An
Coimisiún
Pleanála

Technical Note: Ecology R323410TN

Proposed Limerick City Greenway (UL to NTP) within the townlands of Dromroe, Sreelane, Newcastle and Castletroy, Co. Limerick.

DAU submission, EIAR (Biodiversity) including lesser horseshoe bat, and NIS including Annex I habitat and Annex II species otter.

TITLE
 BRIDGE 2: PROPOSED PLAN ELEVATIONS & SECTIONS

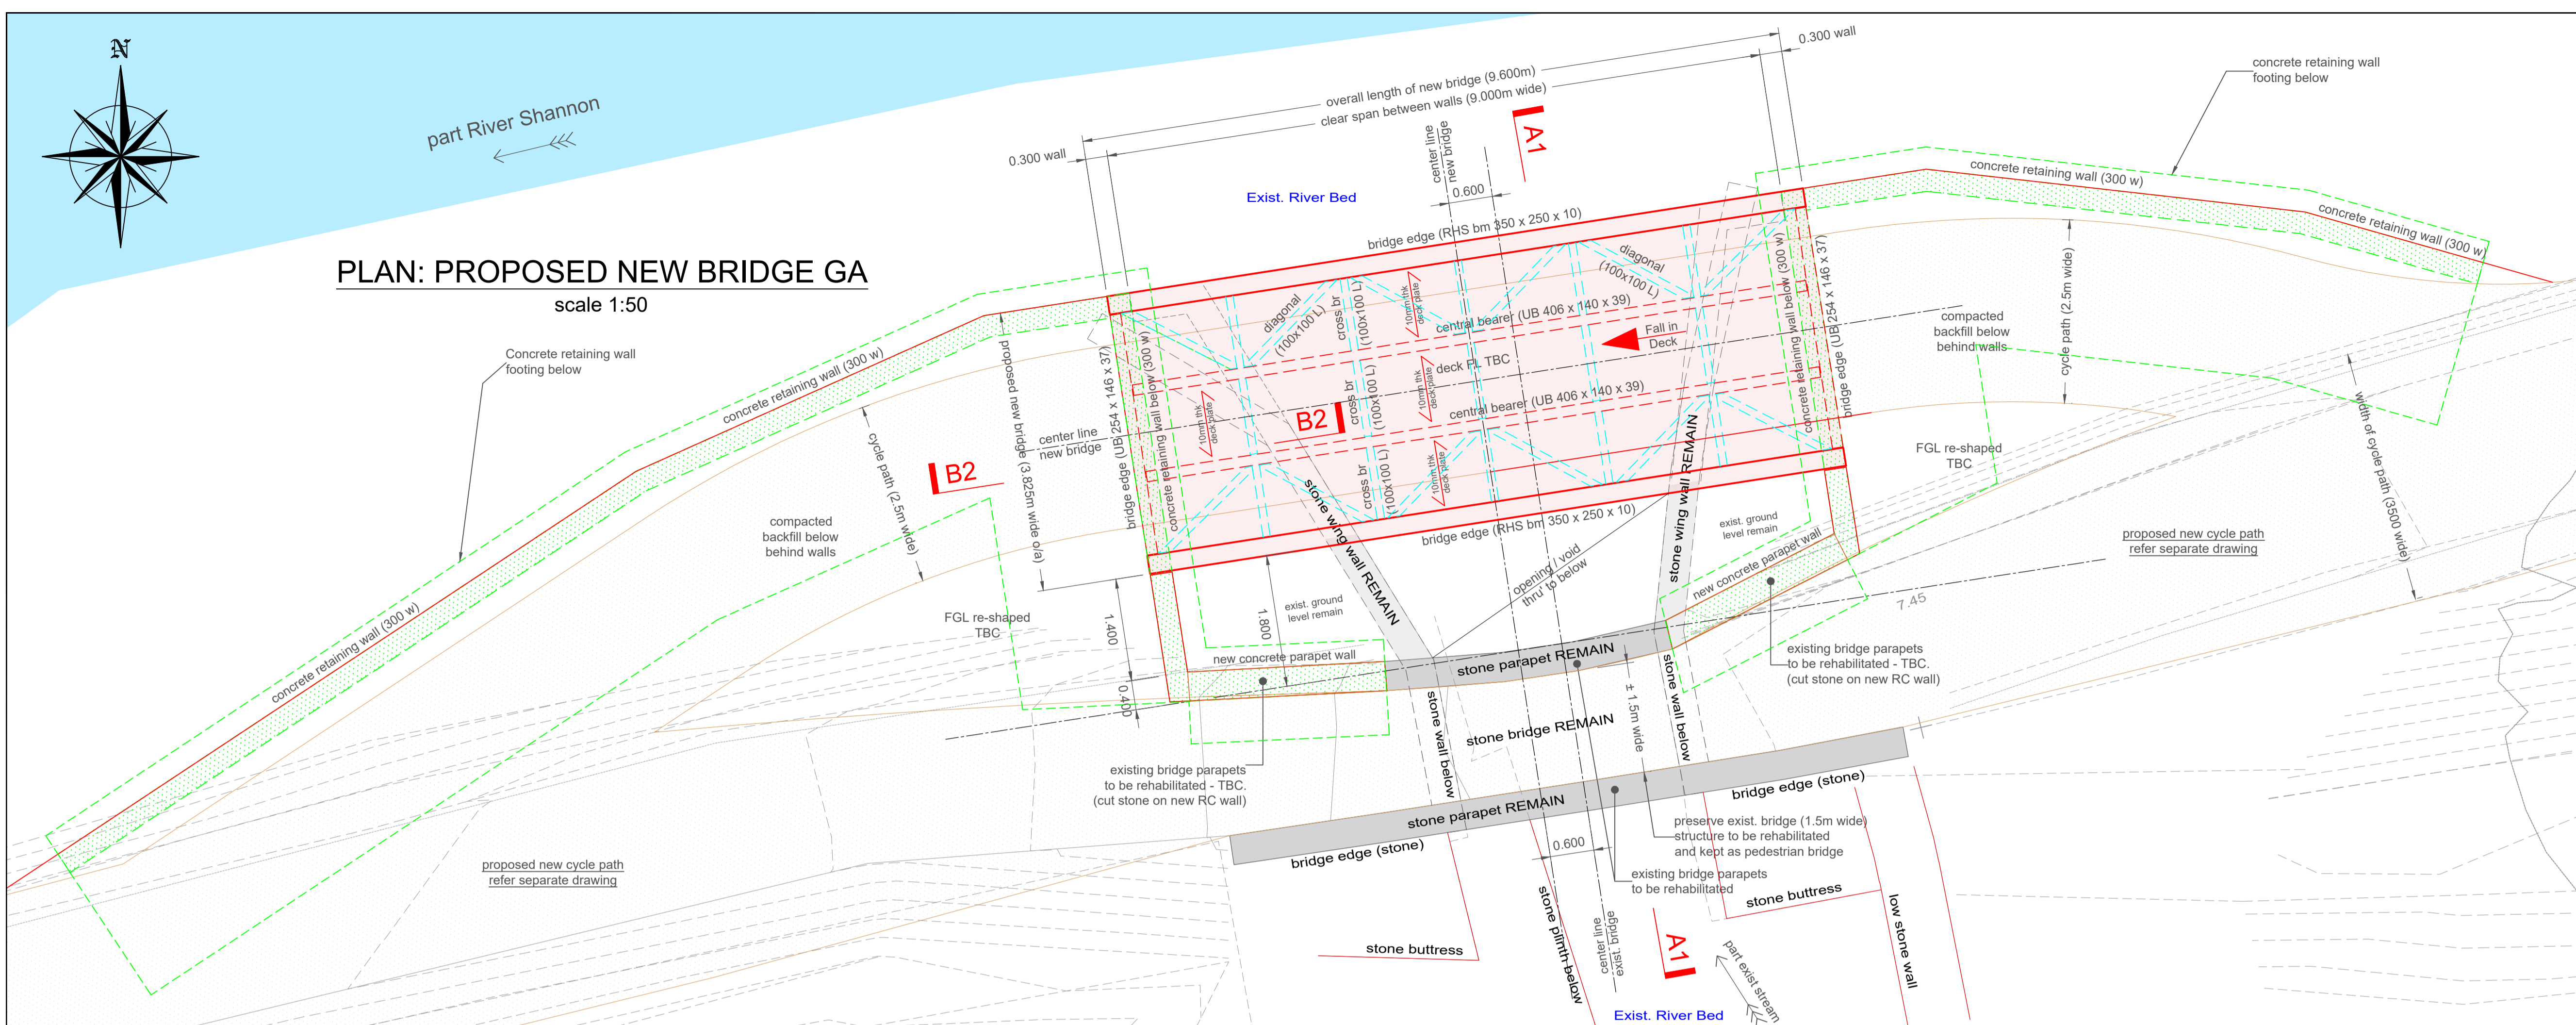
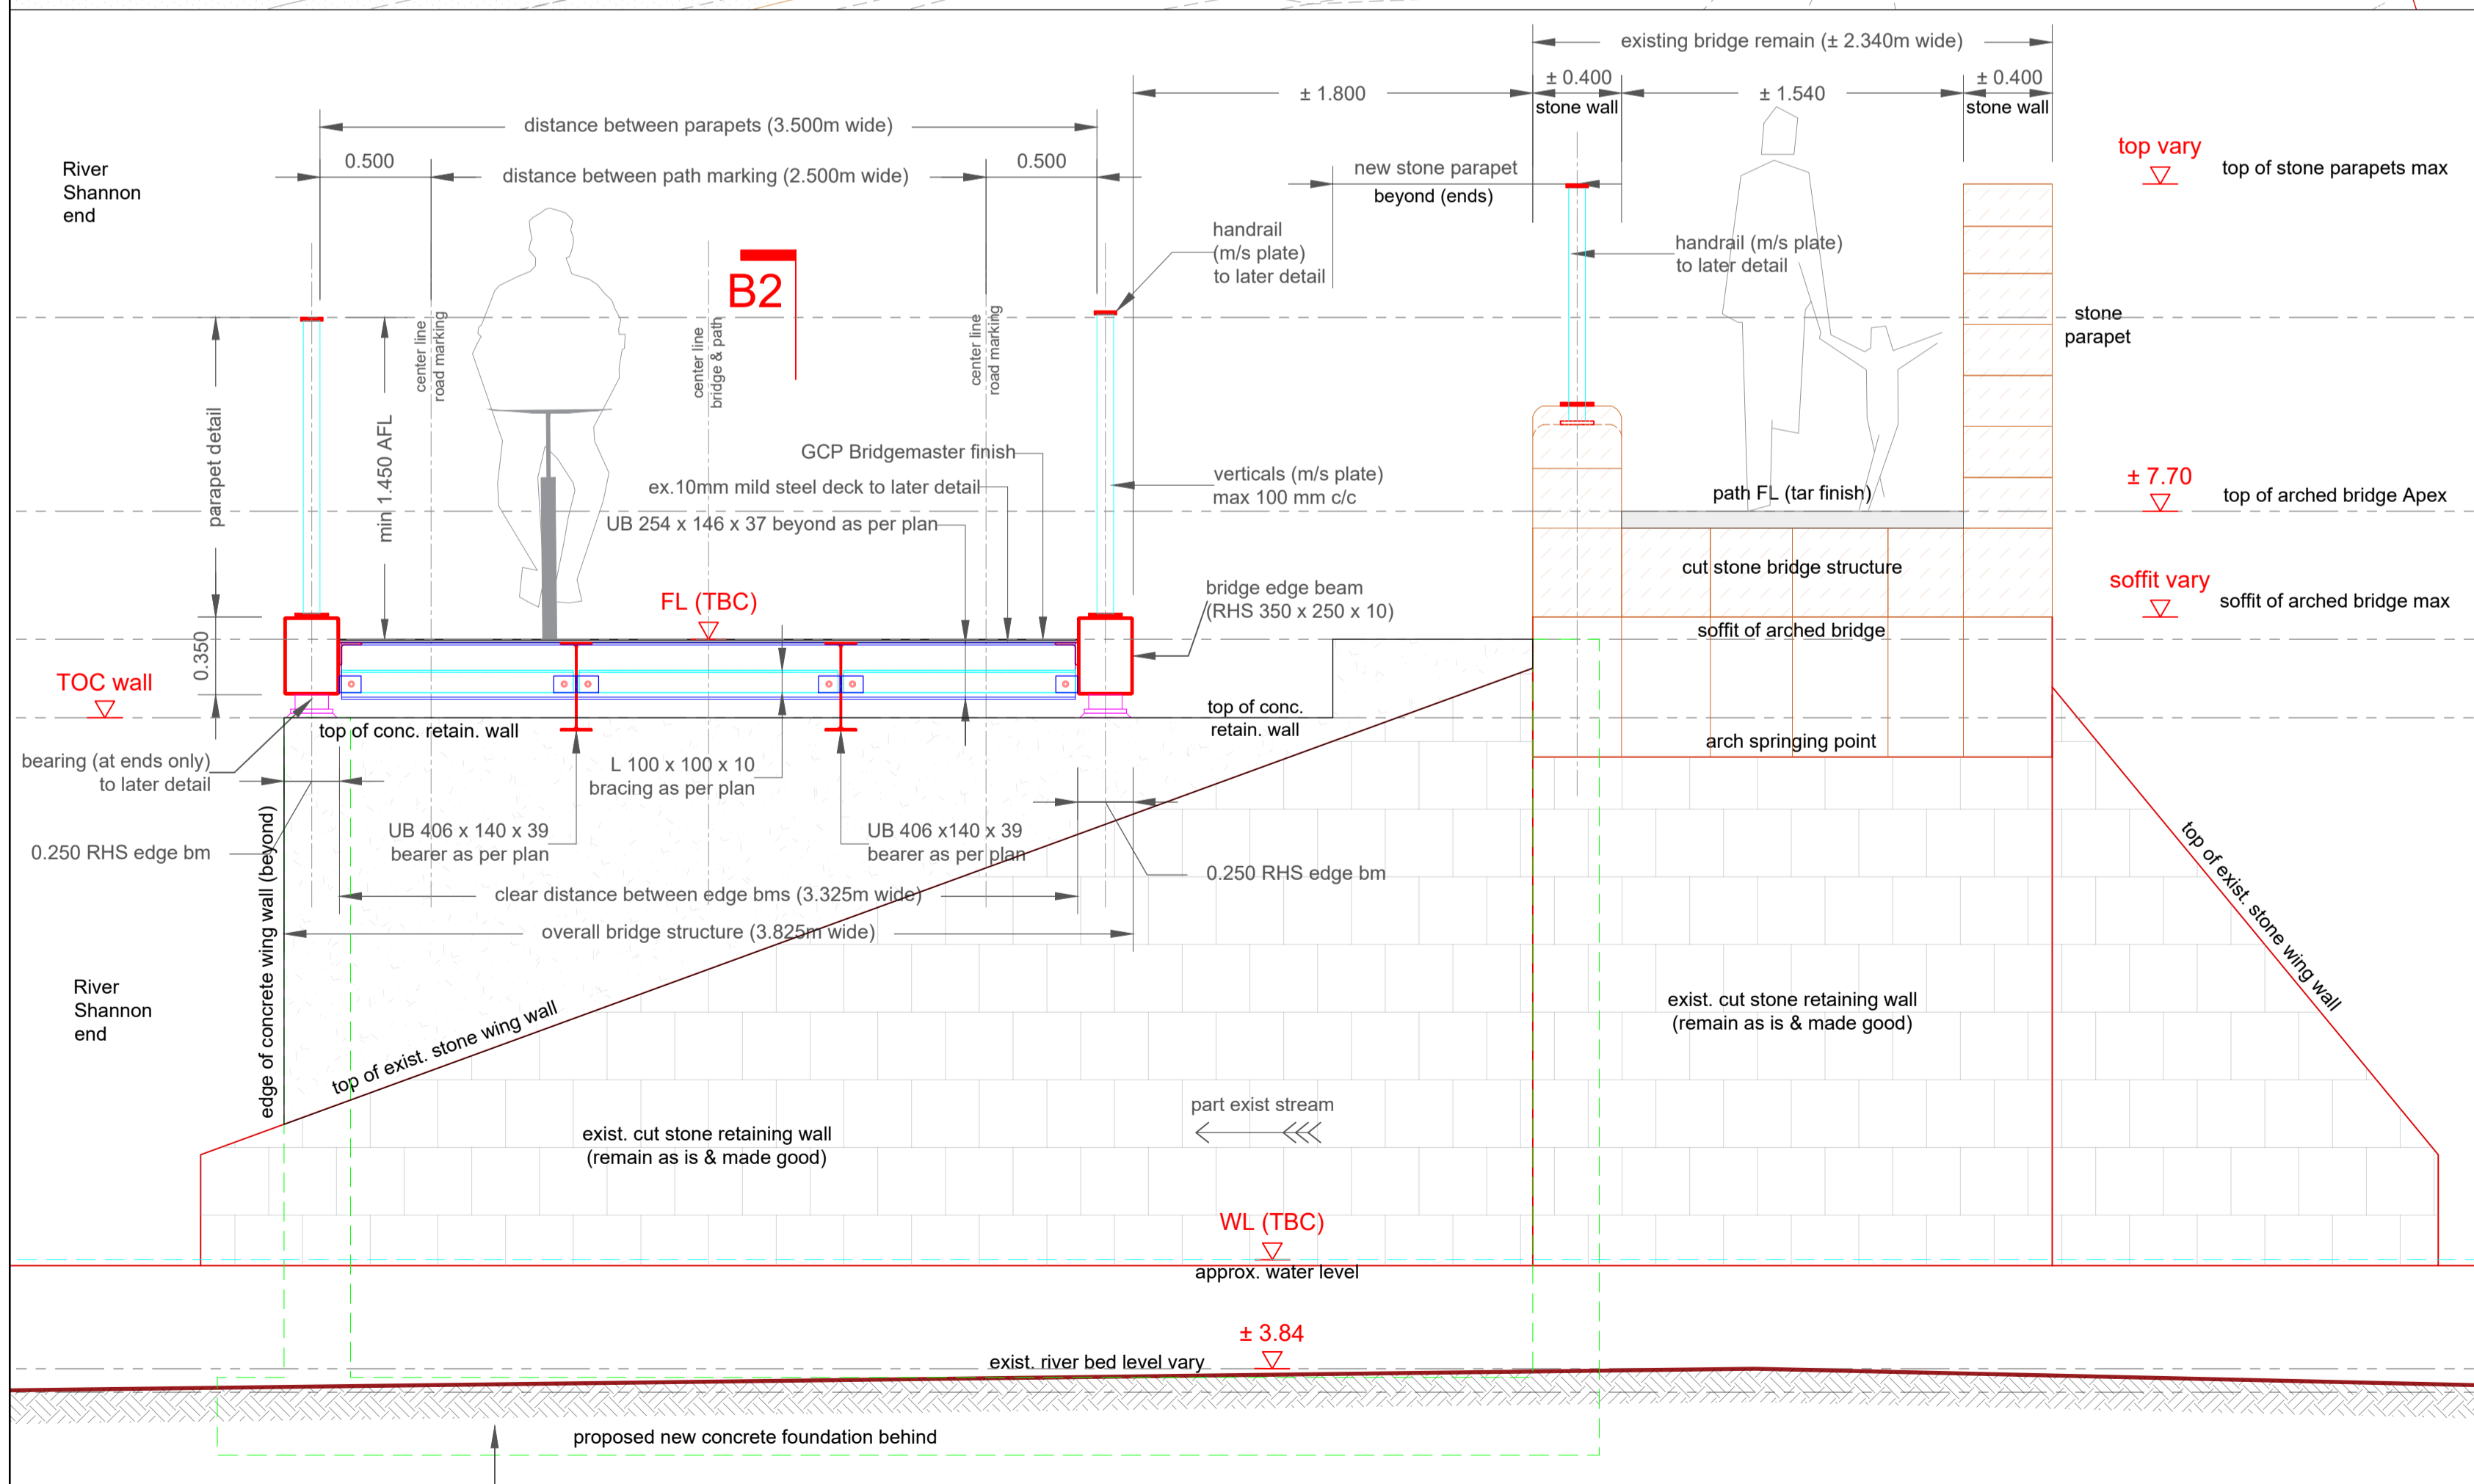
- 3.1.9. It is argued in the application documentation, particularly with respect of the proposed Bridge no.2 at Ch0+970, that alluvial woodland communities recorded here no longer support the structure and function attributes of Annex I habitat 91E0 Alluvial Woodland. While the Structure and Functions of the 91E0 habitat may be in ‘Unfavourable’ condition at this site (e.g. due to a low number of indicator species, cover of non-native invasive species, lack of regeneration etc.), the habitat is still assigned Annex I status⁶. It is also noted in the CO document that there is an absence of suitable terrain to accommodate the expansion of alluvial woodland, therefore the priority for the SAC is to protect and restore existing woodland. The construction of a bridge at this location would effectively impede future restoration of the 91E0 habitat in this area and failure to achieve conservation goals.
